Application No: BN/21/22/PL
Site Address: The Hollies 84 Barnham Road Eastergate PO22 0ES
Description of works: Demolition of existing care home and construction of 5 no. dwellings and garaging, with landscaping and associated works. This application affects the setting of a listed building and is in CIL Zone 2 and is CIL Liable as new dwellings.

Thank you for your internet representation made on 21st March 2022 which has been recorded as an objection with the comments as follows:

NORTH EAST ELEVATION

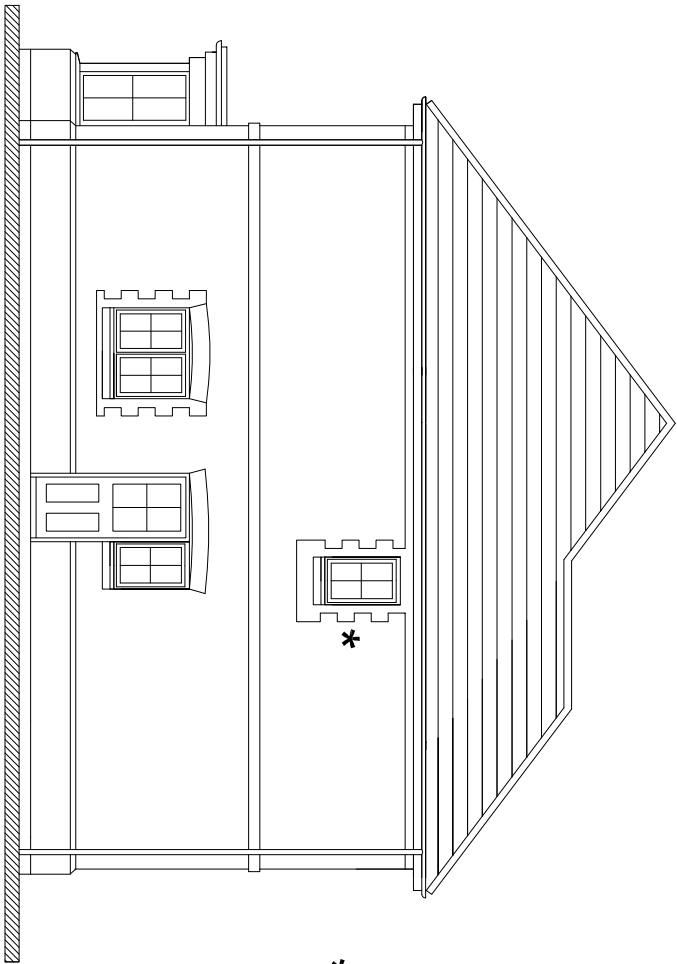
Living on a property that borders this development, at present my only objection would be the second story window on the north east side of plot 5 which looks like it could at worst look directly through the skylights of our side extension, but will definitely overlook our front garden. The bedroom this window is in already has a larger window on the south west side so the north east one could simply be removed to overcome this objection
